Please ask for: Ms Iqraa Malik
Email: iqraa.malik@terraquest.co.uk
Telephone: 01212341390
Our Ref: BE/75/20/HH
Your Ref:
Date: 24th July 2020

Application for Planning Permission for Works or Extension to a Dwelling

Development: Single Storey side extension
Location: 50 Mansfield Road Bognor Regis PO22 9HB

Proposed Block Plan
scale A3 1:500

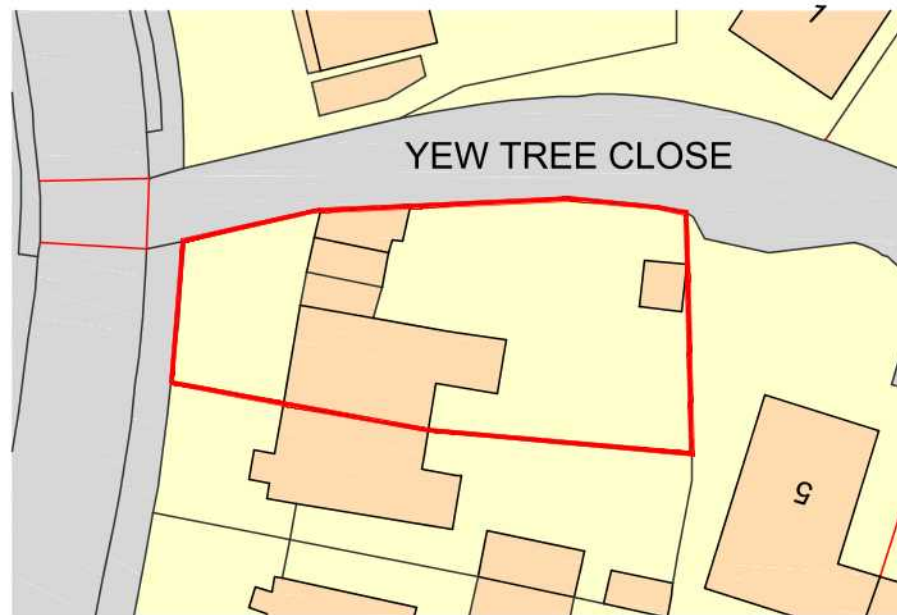
Block Plan

You are required to have dimensions from the proposed extension(s) to all site boundaries. Please amend.

DATE JULY 2020	DRAWN BY LF	PROJECT 50 Mansfield Road, Bognor Regis, PO22 9HB	JOB NO. 117	DRAWING TITLE Existing Plans-Elevations
	CHECKED BY LF	DRAWING NO. 117 - 02	REV A	STATUS Planning

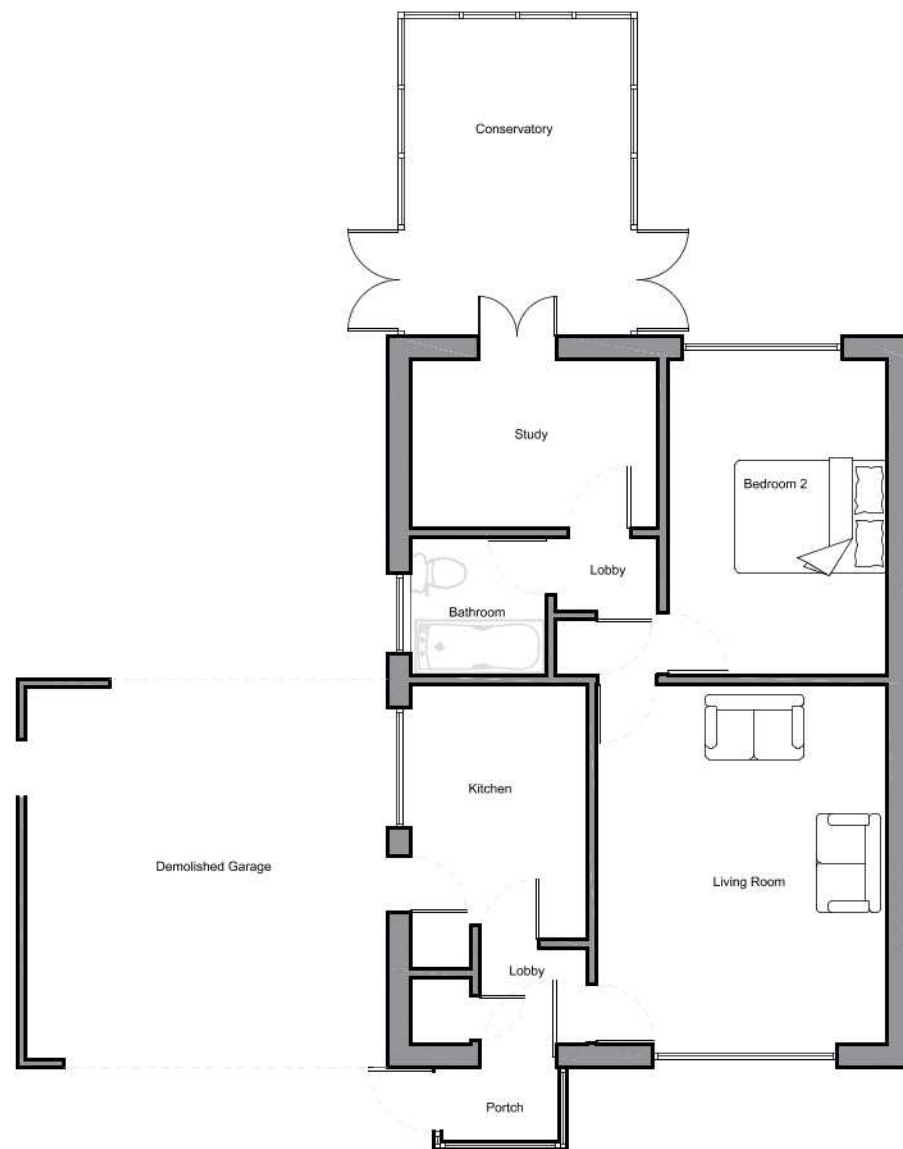
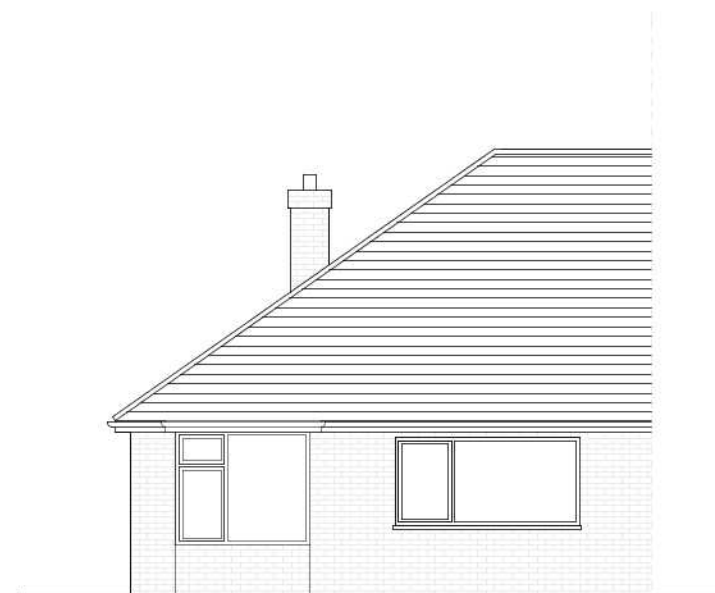
All Plans

All plans require a scale bar. Please amend.
